From: Susan Leeson [REDACTED]
Sent: 25 August 2021 12:47
To: Simon Davis <Simon.Davis@arun.gov.uk>
Subject: RE: Brookview Nursery WA/58/21/PL

Subject: RE: Brookview Nursery WA/58/21/PL

Proposed Block Plan
Scale 1:500

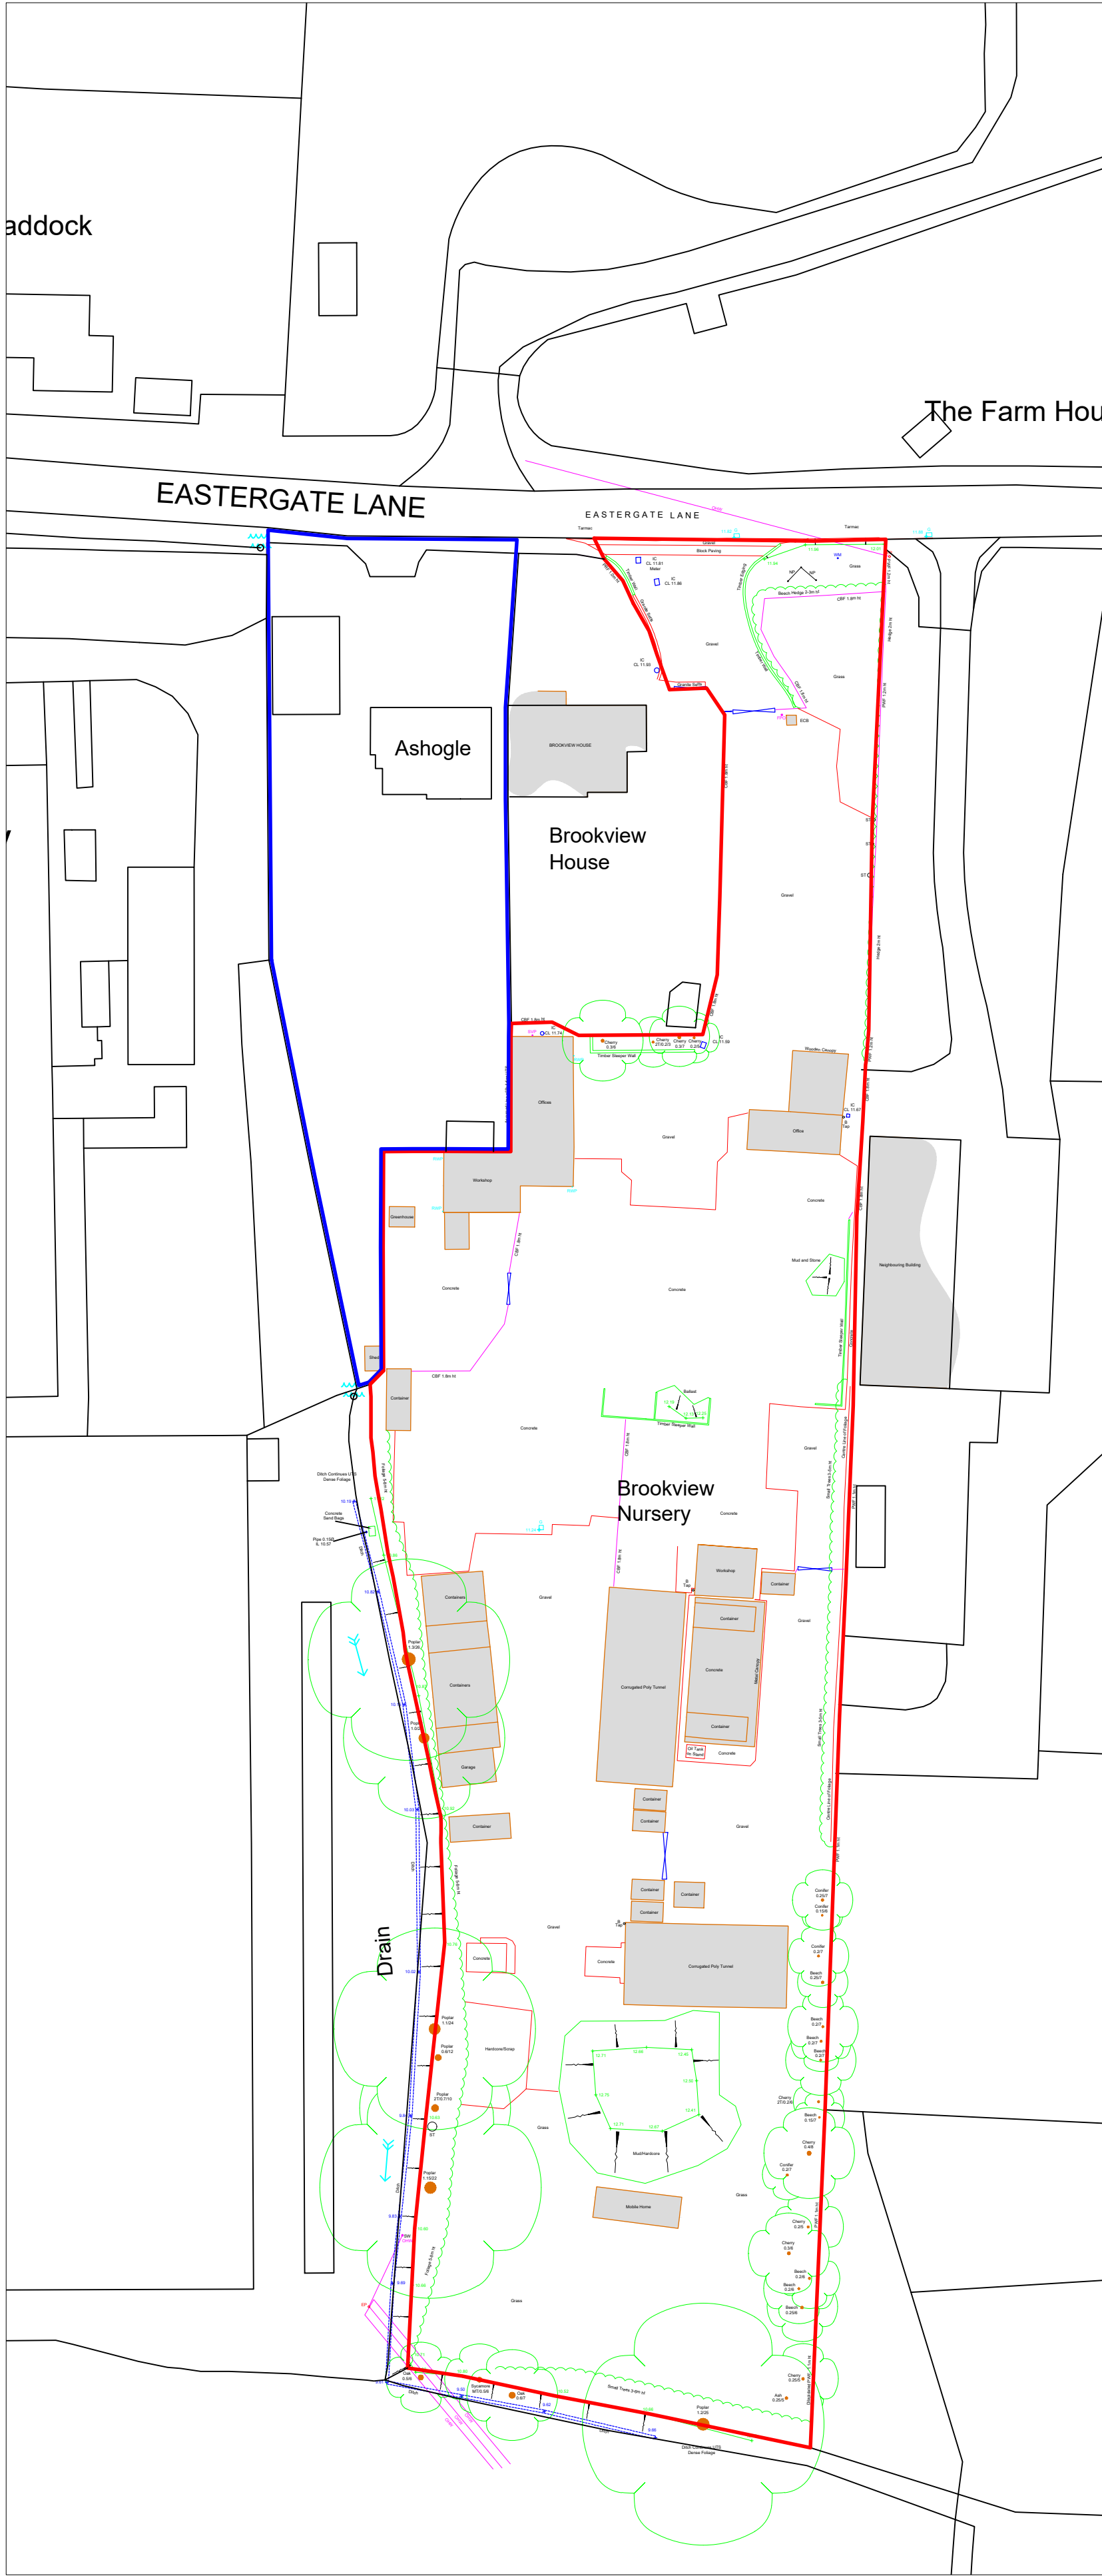
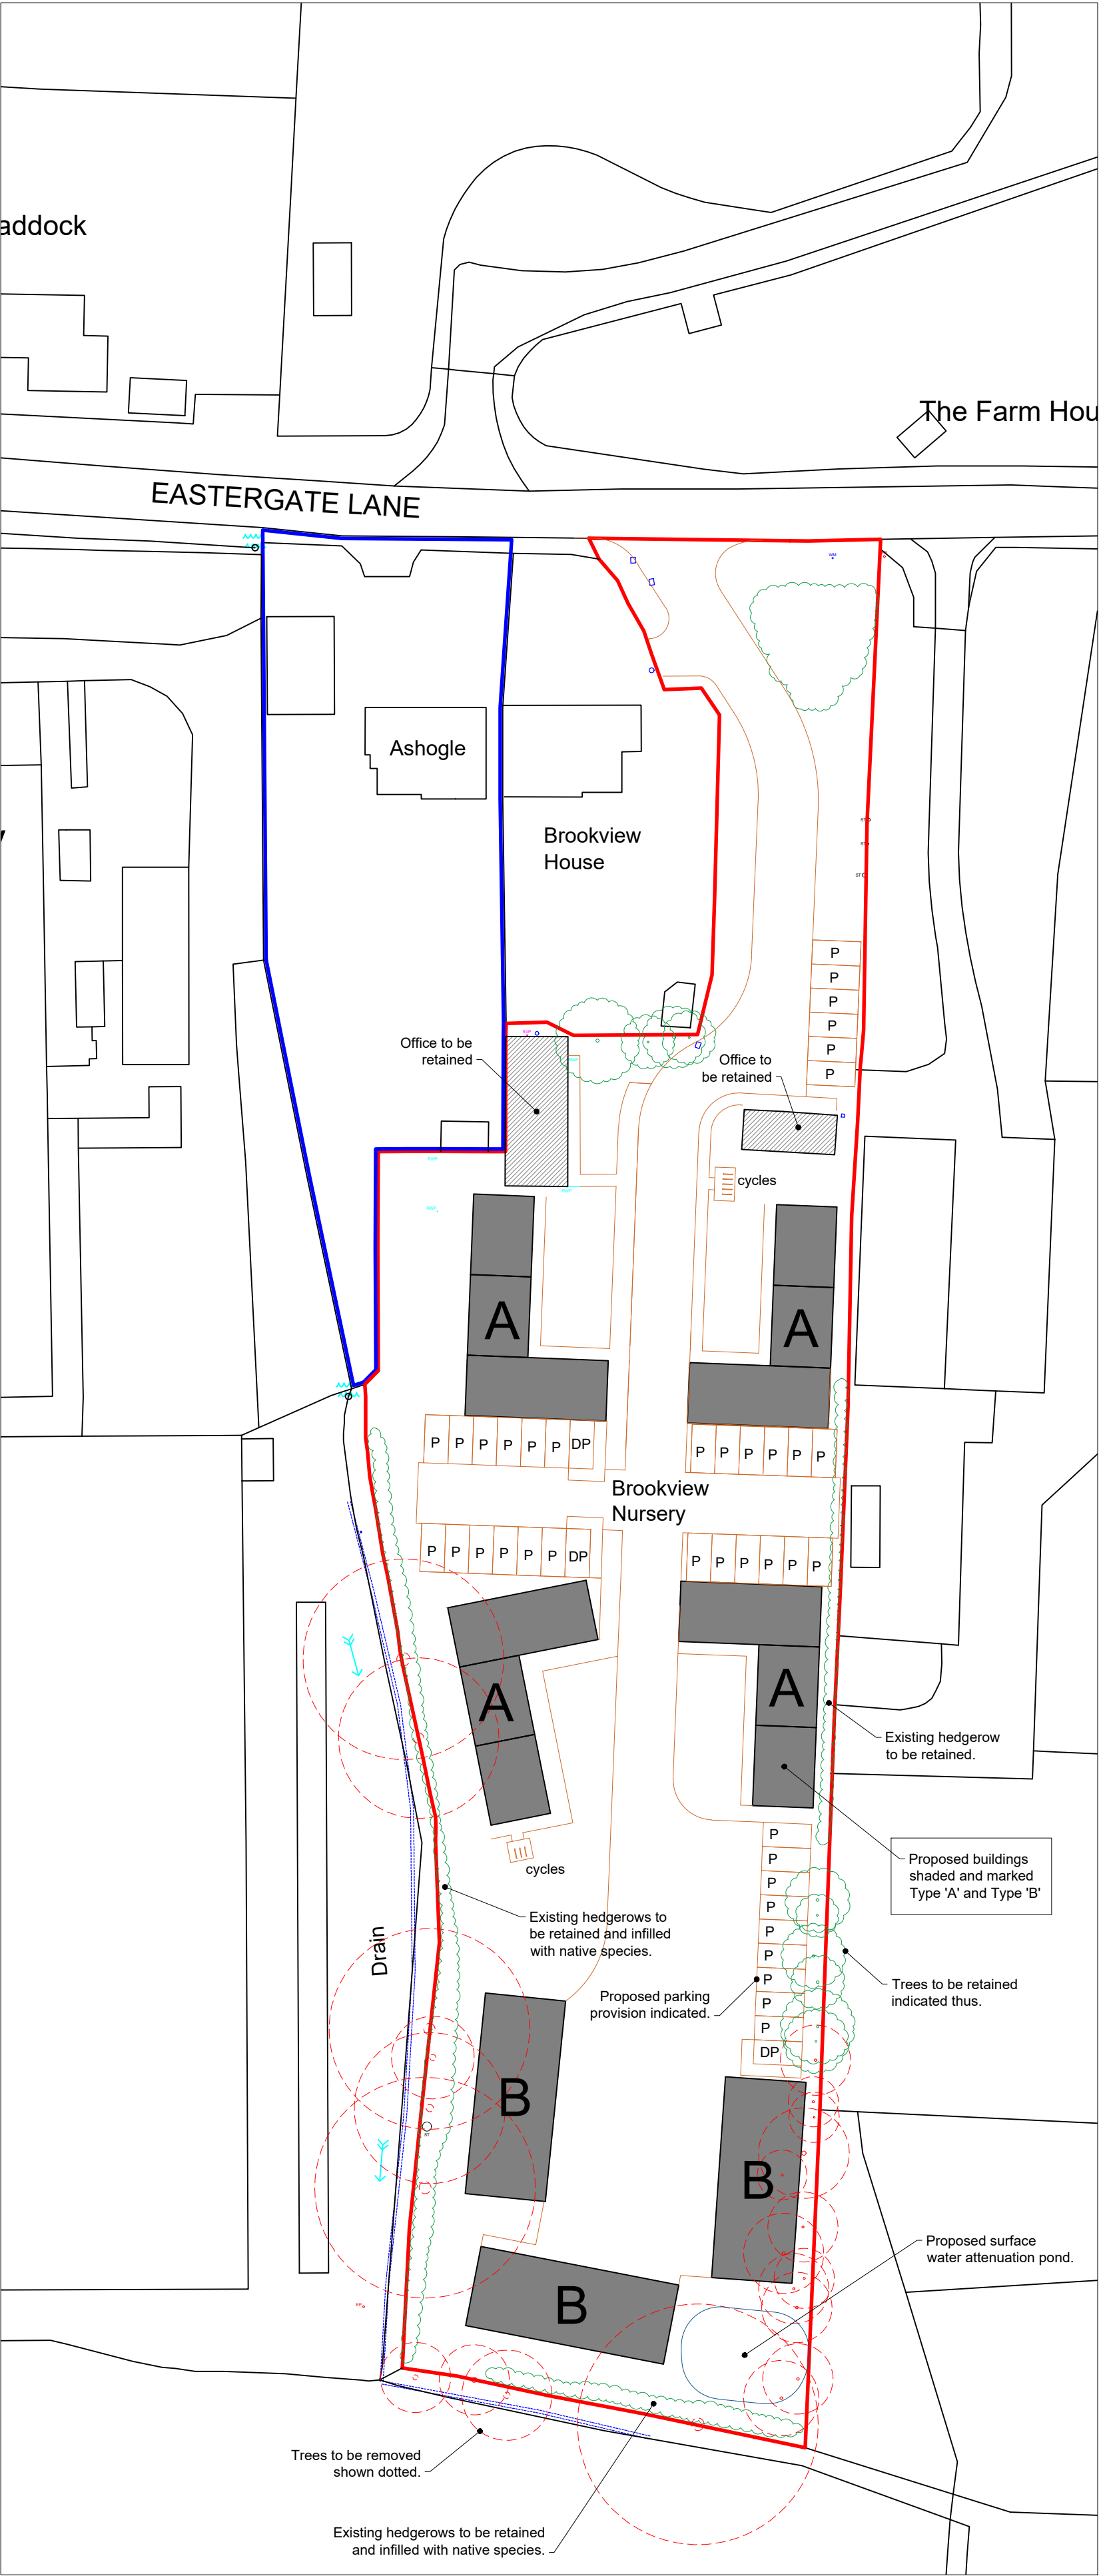
The WNP also has a new biodiversity corridor policy. One of these is Wandleys Copse and the WNP suggests that it goes through your site (see green line below). It probably actually goes down the western side and then along the southern end following the line of the ditches before heading south again but the WNP shows it going through the site and so without clarification, I have to deal with it as shown. If you want to query this, I suggest you speak with the Parish.

Anyway, I note that you are proposing to remove trees along the western and southern boundaries and so I think you would be in conflict with policy VE10 which states:

Proposals will not be supported where there is evidence that the proposals would significantly harm biodiversity, unless it can be adequately avoided, mitigated, or alternatively the subject of compensation. Where proposals have an impact on Biodiversity rich habitats, a management plan shall be provided to ensure that the long-term protection and enhancement of the habitat can be achieved.

This conflict is likely going to make this very difficult to get through the DC Committee. You may be able to resolve this by layout changes/biodiversity net gain proposals.

Further speaking of which, you have not provided any tree survey so we cannot assess the impact on trees. I have consulted the Tree Officer but if he does respond, he will only say that no tree survey has been provided. Sorry for not spotting this previously but this does need to be provided.

I note the issue you have raised and I will talk to the client with regards to the B8.

Regarding the biodiversity corridor, as you are aware, the ecology survey as previously requested (Shadow HRA), is taking place on 31st August. You confirmed by email of 17th August that "it is ok as this is a major we still have 2 months to go", therefore it would be unreasonable to take this to committee without allowing this report to be submitted. This would give us time to make the requested amendments.
